The Member Secretary,  
Chennai Metropolitan  
Development Authority,  
No.1, Gandhi Irwin Road,  
CHENNAI -600 008.

1/20569/2001

22-11-2002

Area Plans Unit - Planning Permis-  
sion - Construction of Ground+3 Floors  
Commercial Building at Arcot Road, Devi  
Karumariamman Nagar, S.Nos.83pt and 84pt  
of Valasaravakkam Village - Remittance of  
charges and submission of revised plan -  
Regarding.

SHEET NO: 1  
 TITLE: SITE PLAN  
 NOTE: ALL DIMENSIONS ARE IN METRE  
 FILE NAME: D:\Nivalan\Nivalan\Site\Site  
 SCALE: P.A.100 (1" TO 80')  
 DATE: 01.11.2002  
 DRG NO: COPRN REV NO: 7  
 DRN BY: A.P. K. RAVI  
 D.P.

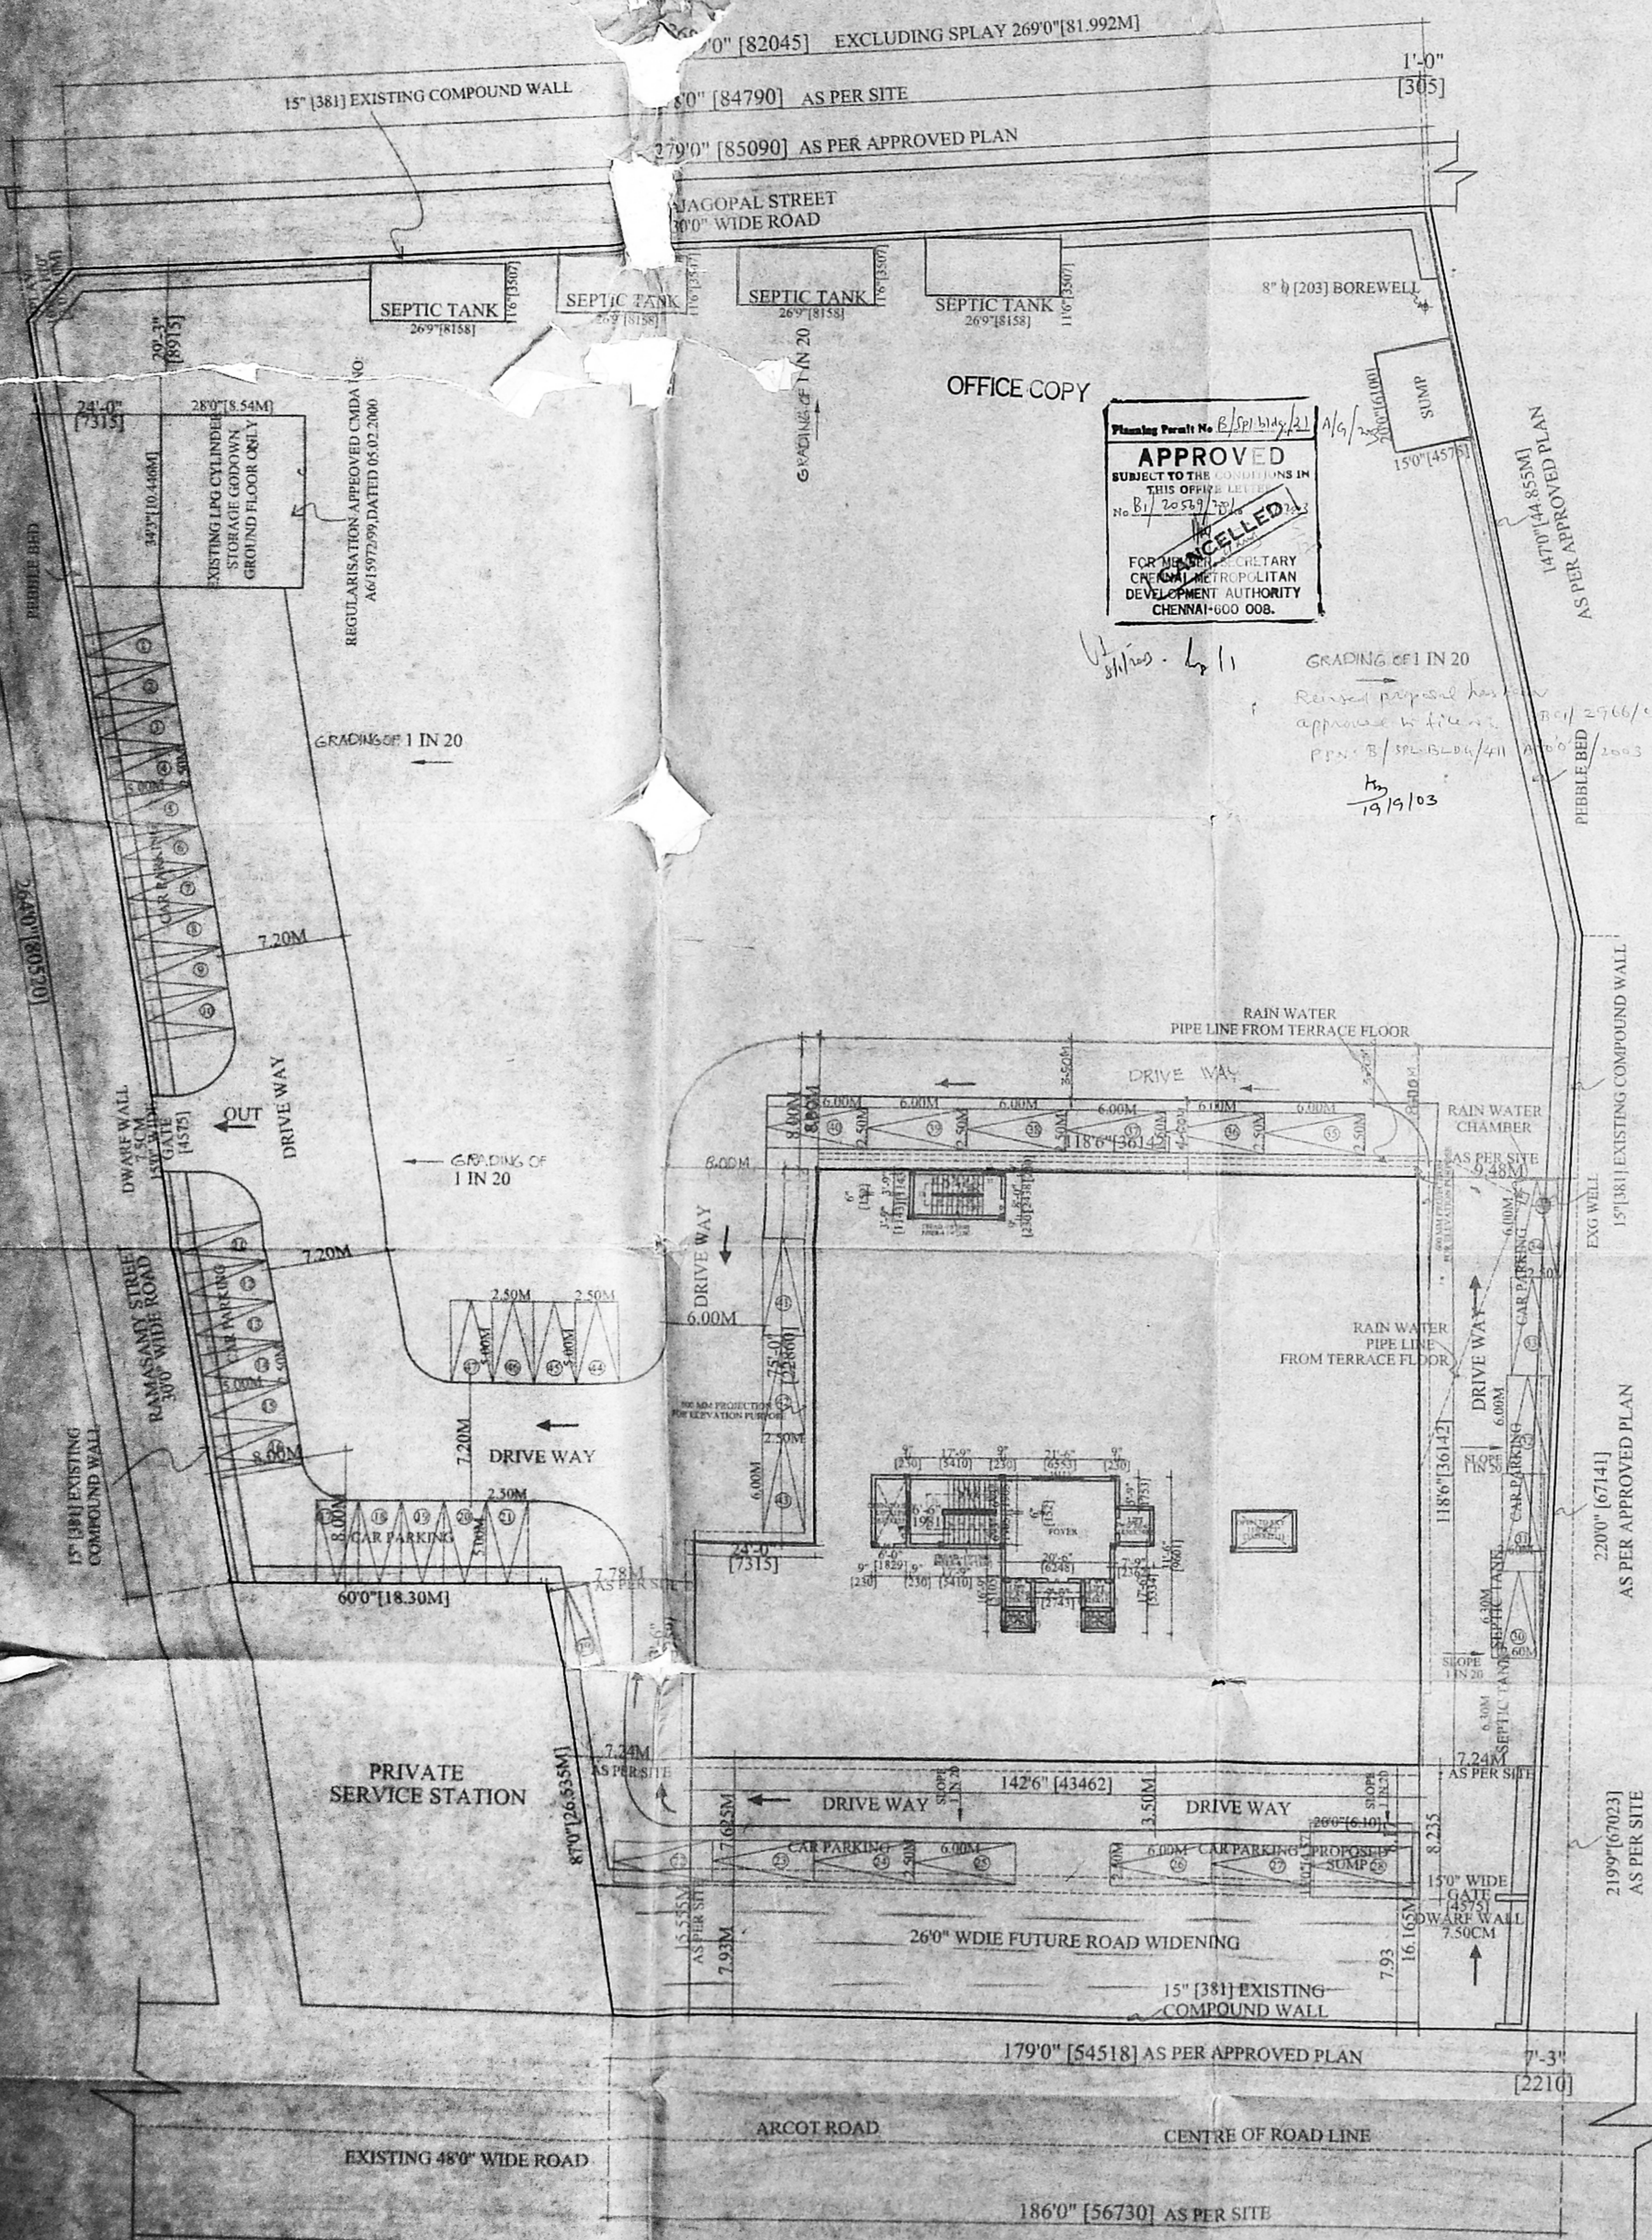
- 5) You are also requested to furnish 5 sets of revised plans rectifying the following defects:
- i) Front Set Back indicated in the site plan, needs correction.
  - ii) The 'open' shown in the plot frontage shall be deleted and accordingly the plans are to be revised.
  - iii) Grading of 1 in 20 towards pebble bed shall be shown in the set back spaces in the site plan and pebble bed detail and the Rain Water Harvesting structures shall be shown around the site except the gates.
  - iv) Floor areas mentioned in the legend, needs correction.
  - v) The car parking lot arrangement shall be revised complying Development Control Rules in respect of driveway and turning radius. (Totally 47 car spaces required and the parking lots numbered as 25 & 33 obstructs driveway requirement)

- ⊙ vi) The date of approval of existing Godown shall be corrected as "5-2-2000" instead "5-2-2002".
- vii) Side Set Back on the east shall be corrected as found in the earlier approved plans.
- viii) The note on CMDA's earlier approval shall be appropriately corrected as "CMDA's earlier approval Lr.No.82/29021/2000, dated 20-3-2001".
- ix) The usage of the area i.e., proposed closure of "Atrium" shall be indicated and the dotted lines deleted.
- x) The dotted lines shown in the place of staircases (in the earlier plans) on the southern side shall be deleted.
- xi) You are also requested to surrender the original approved plan along with planning permit and the approval letter.
